PLANNING APPLICATION CONSULTATION RESPONSE

Application Number:	3/2024/0042
Proposal:	Approval of details reserved by conditions 6 (road adoption), 10 (surface water drainage scheme), 11 (surface water drainage operation and maintenance) , 12 (surface water drainage verification report), 13 (details of play equipment), 14 (protected species licence), 17 (electric vehicle charging points), 18 (external levels and finished floor levels), 21 (boundary treatments) and 22 (biodiversity enhancement) of planning permission 3/2023/0100.
Location:	Land west of Preston Road Longridge PR3 3BE

Lead Local Flood Authority Position

Drainage Proposals

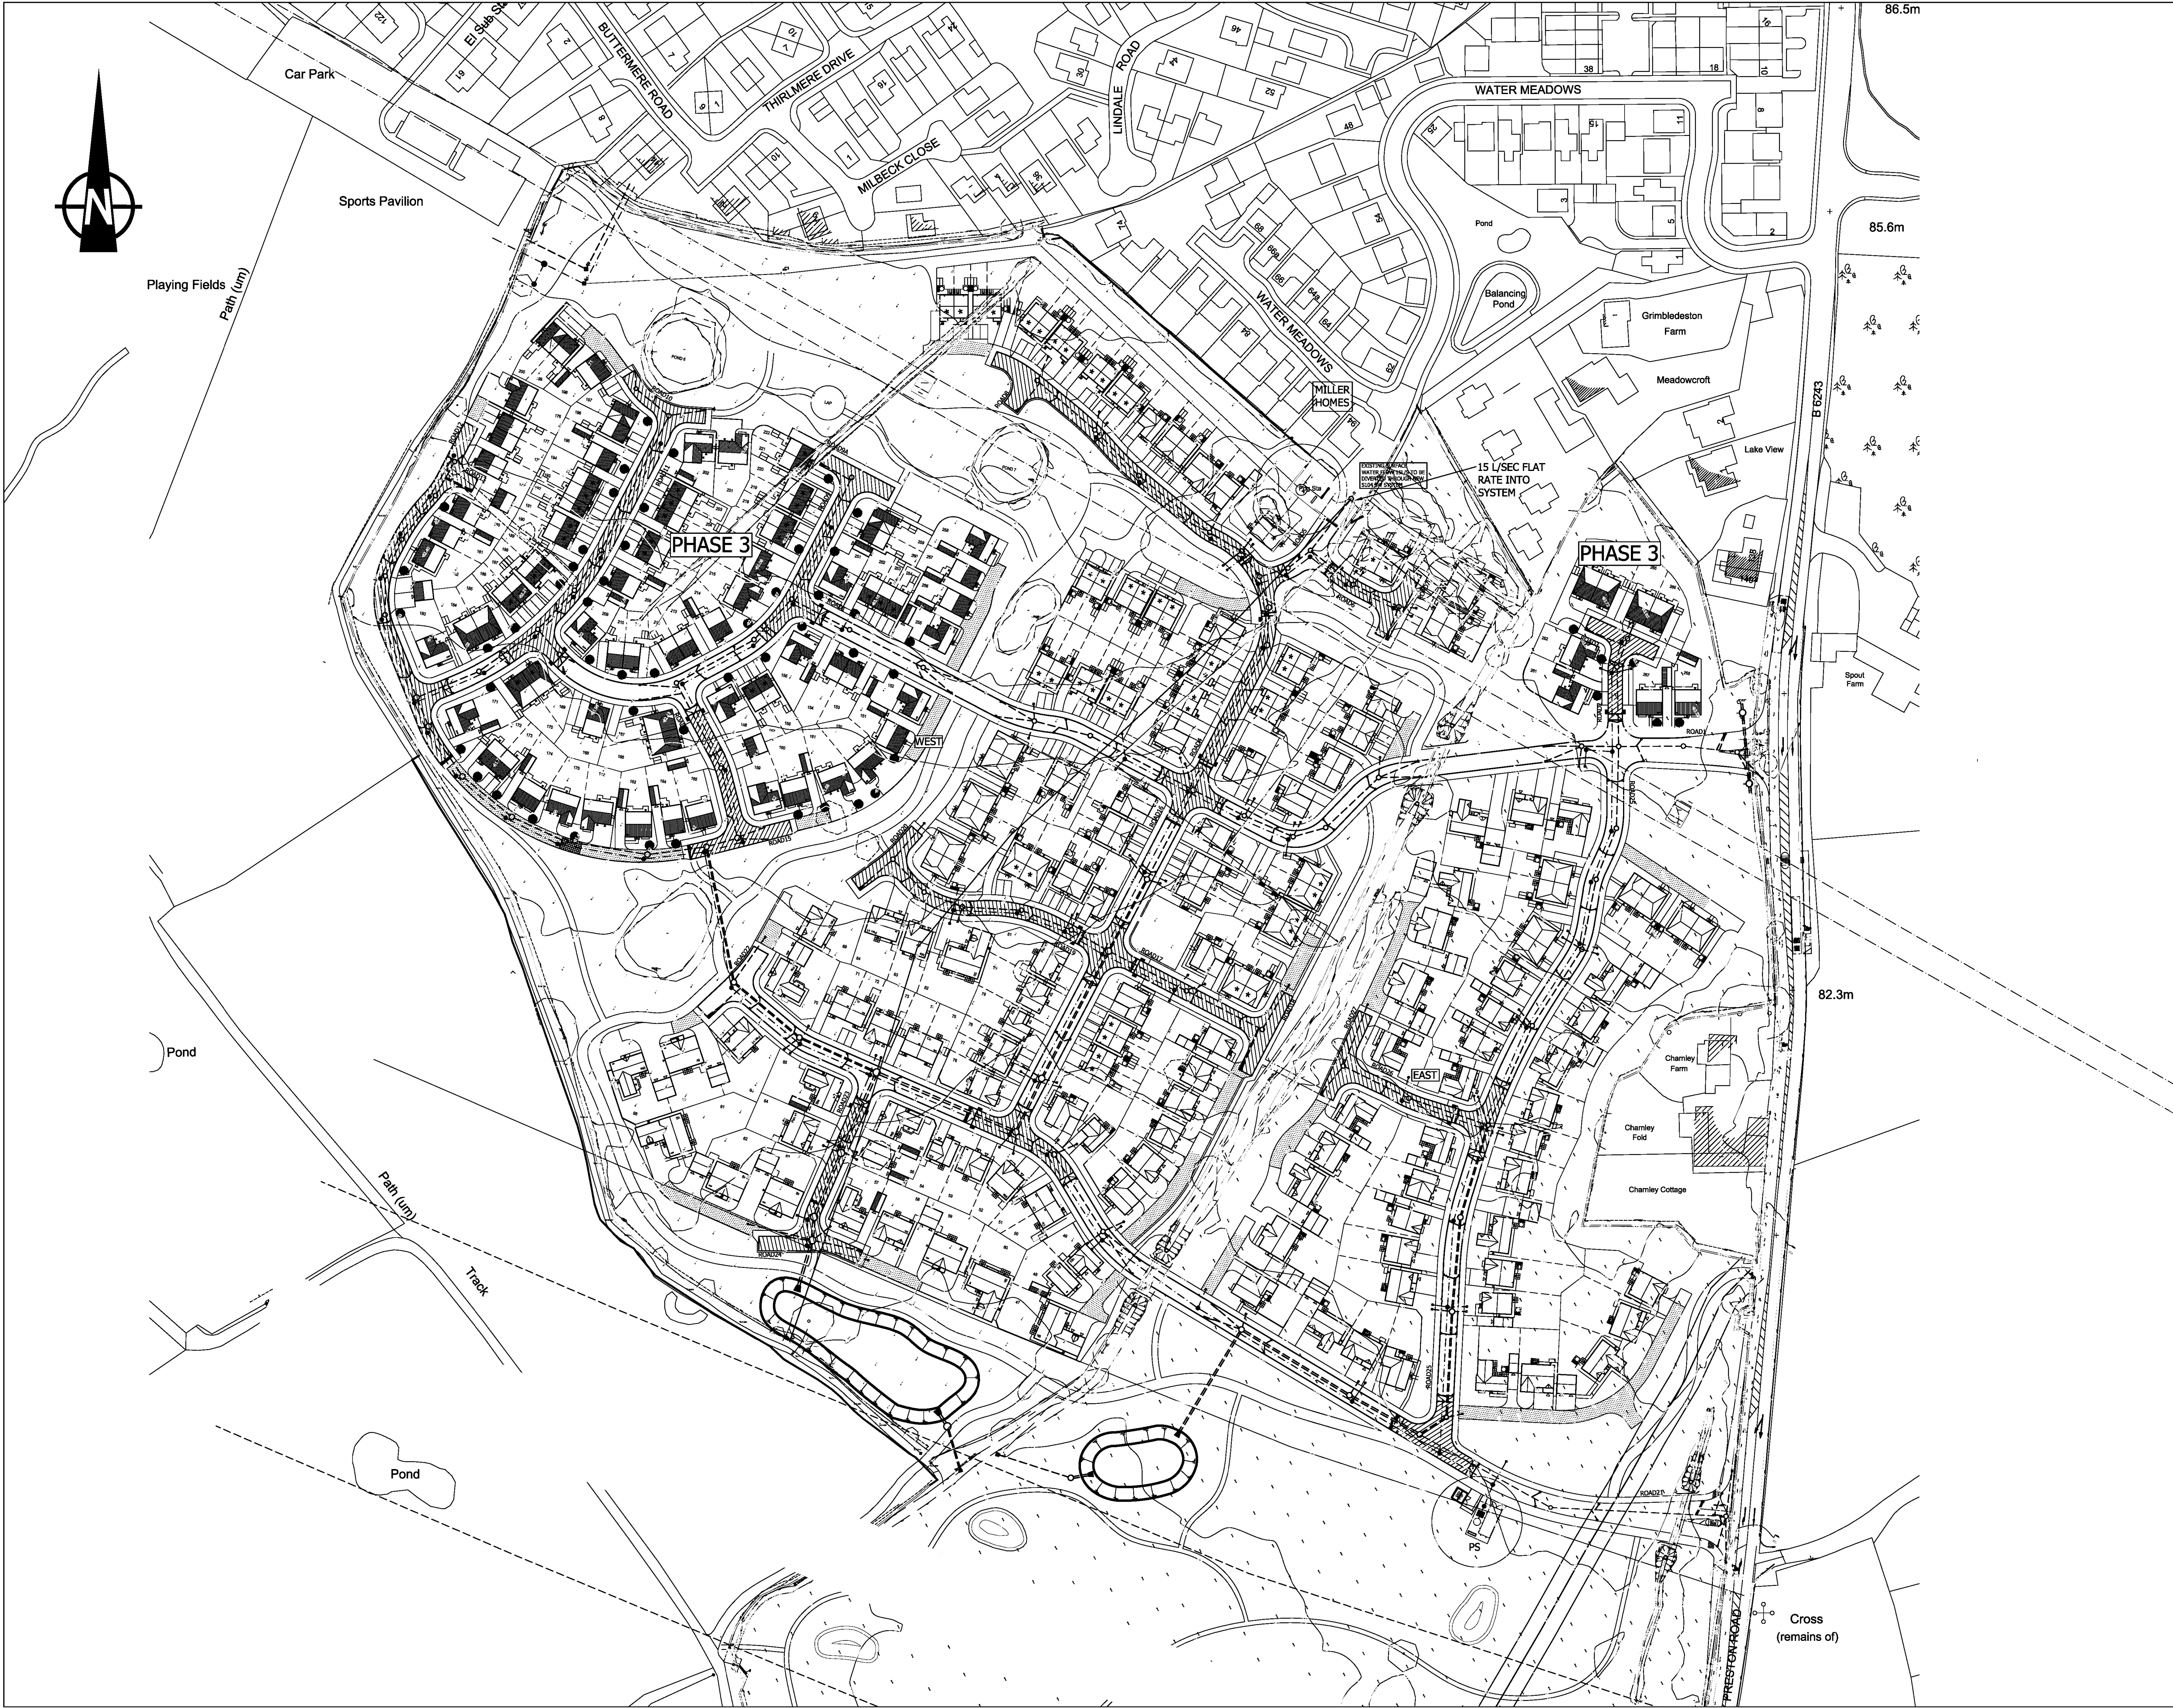
- The applicant has failed to provide evidence of the sustainable drainage system layout showing all pipe and structure references, dimensions and design levels; to include all existing and proposed surface water drainage systems up to and including the final outfall. The adoptable drainage layout drawing fails to do this in its entirety.

- The applicant has failed to provide evidence of whom to contact if pollution is seen in the system or if it is not working correctly.
- The applicant has stated that the attenuation basins have been designed for the 1in100 year event with a 30% climate change allowance, which is contrary to the requirements as outlined in condition 10.
